Application No: A/25/21/A
Site Address: Land South of Water Lane Angmering
Description of works: Erection of 5 No. non-illuminated Banner flags and 10 No. non-illuminated Totem signs.

Thank you for your internet representation made on 9th March 2021 which has been recorded as an objection with the comments as follows:

- 2** Static Banner Flag
- 3** Main Sign Totem
- 4** Secondary Sign Totem
- 5** Secondary Sign Medium
- 6** Secondary Sign Standard
- 7** Secondary Sign Standard
- 8** Secondary Sign Standard
- 9** Secondary Sign Standard
- 10** Secondary Sign Standard
- 11** Secondary Sign Standard

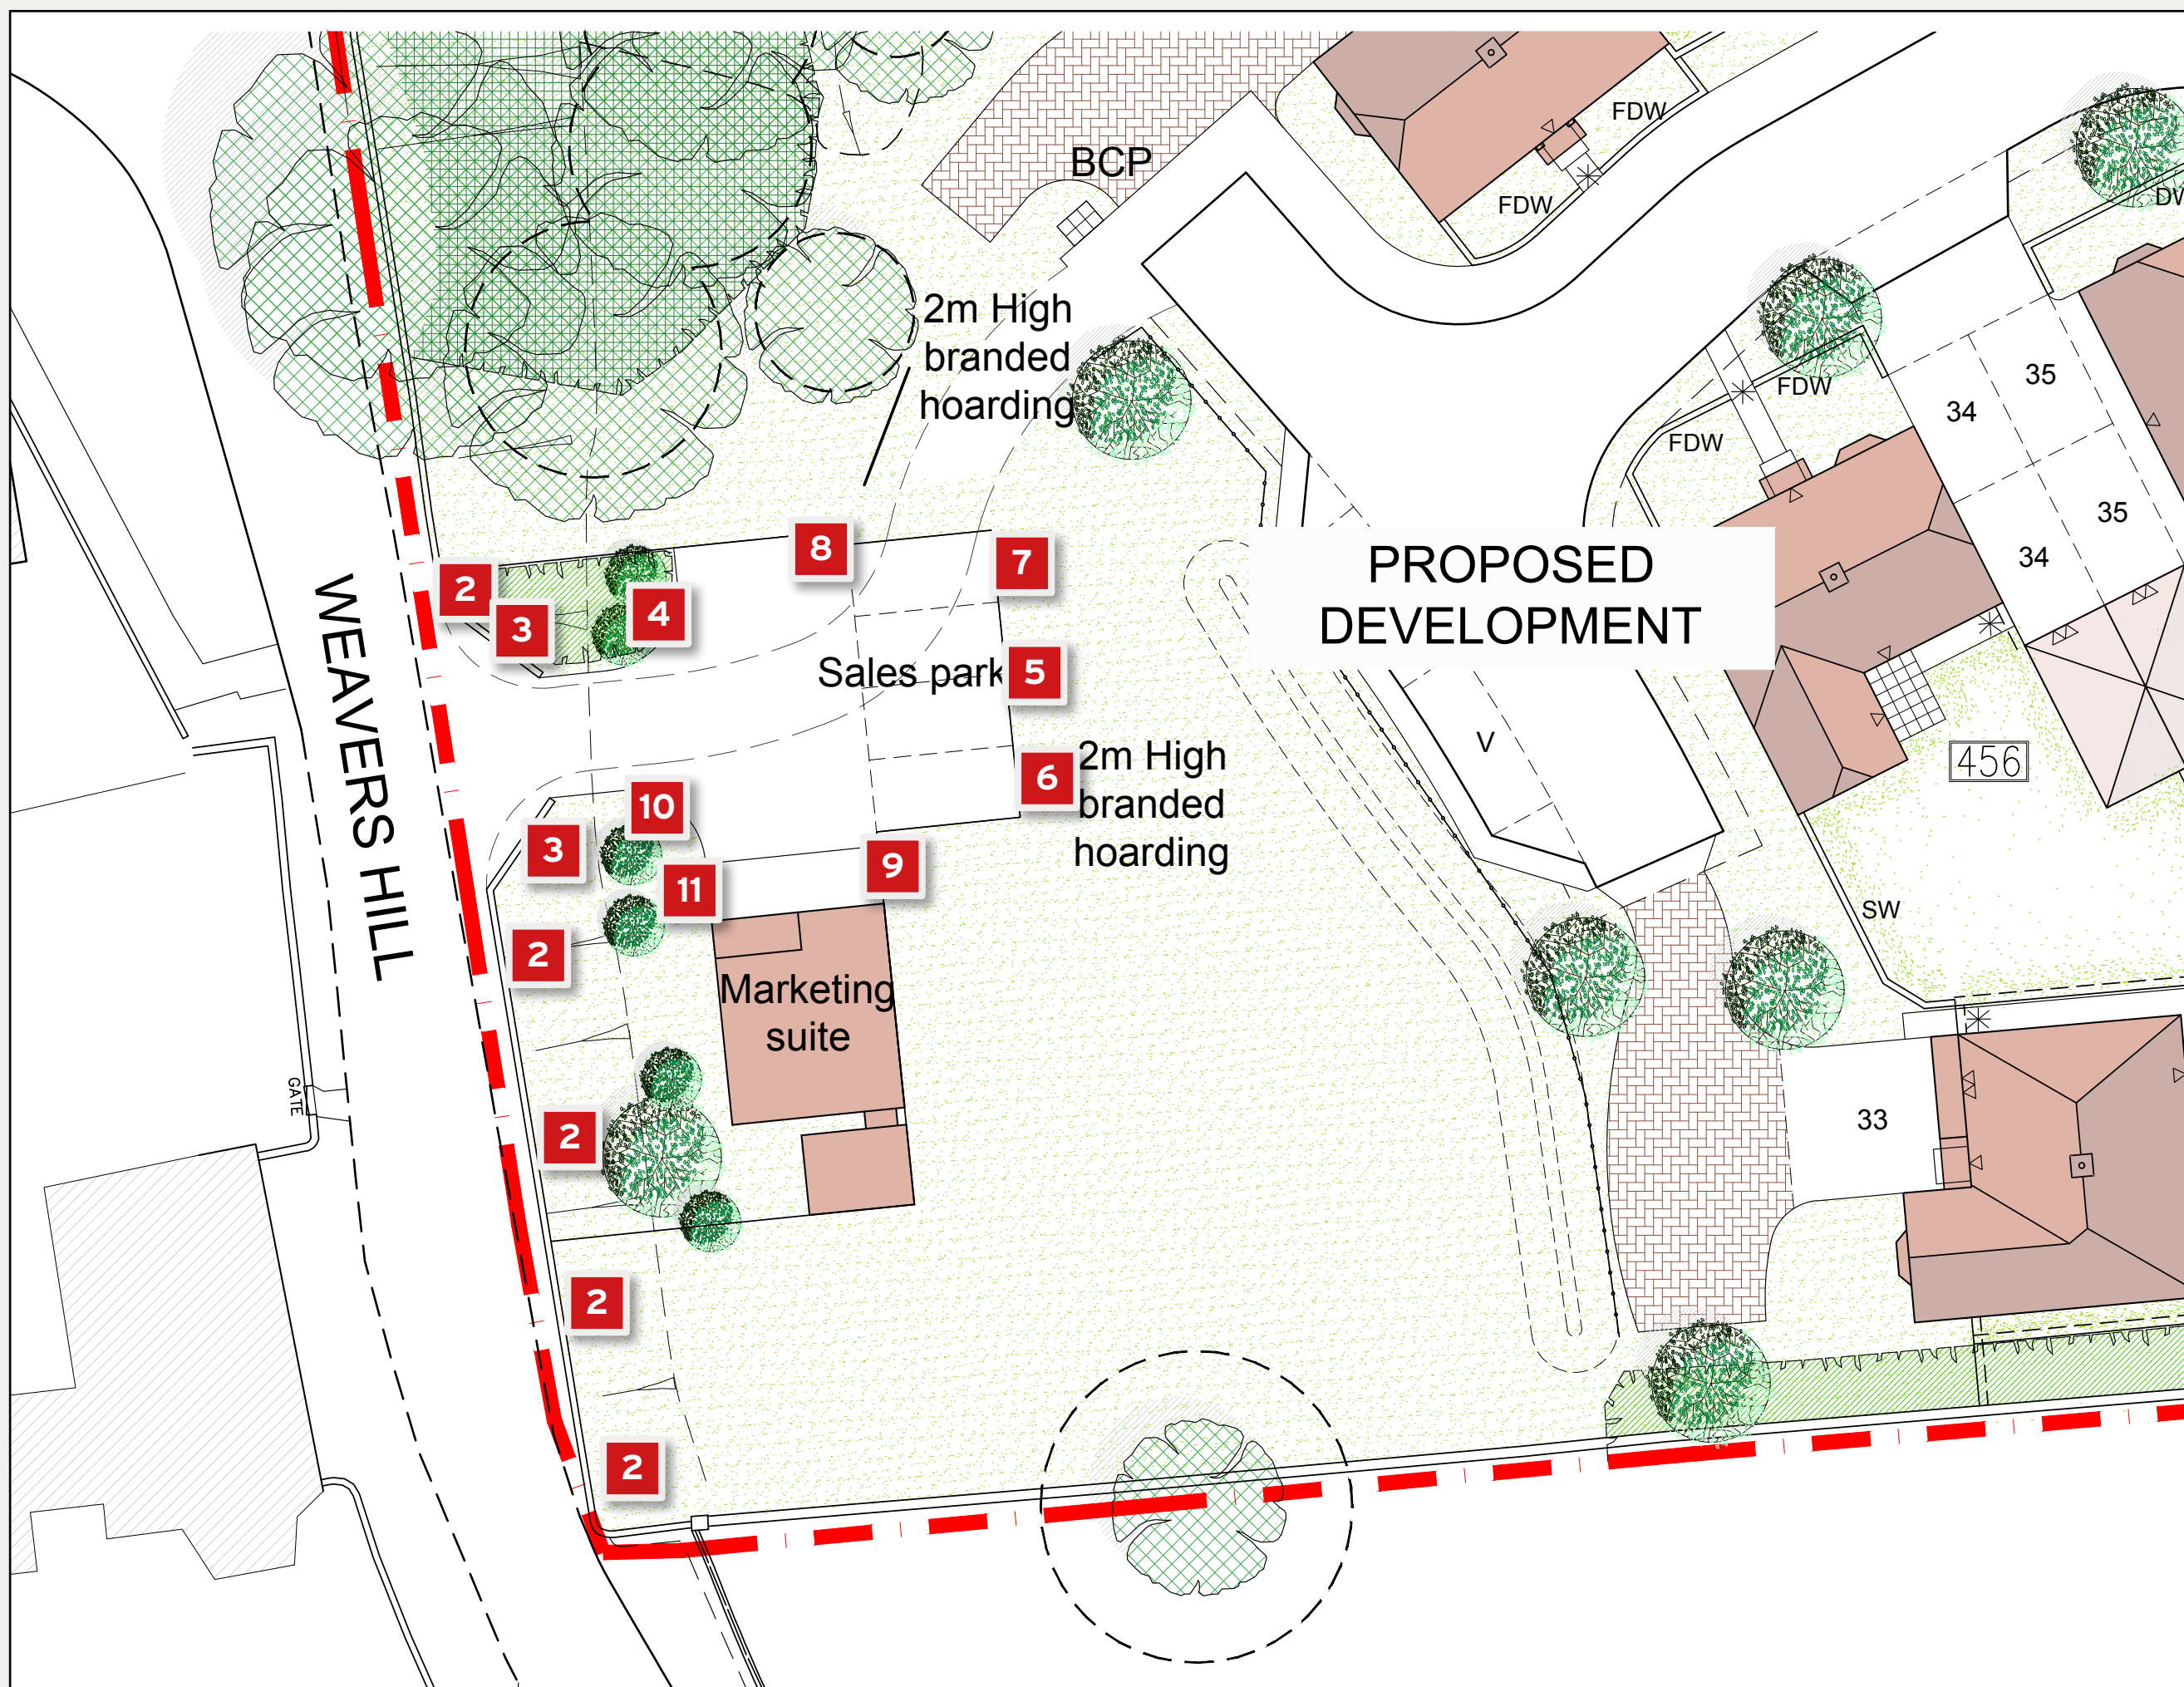
The proposed flags and totems are out of character with the Angmering Conservation area that they abut. They could also be a hazard/distraction for vehicles on a very narrow lane and immediately before a blind corner.
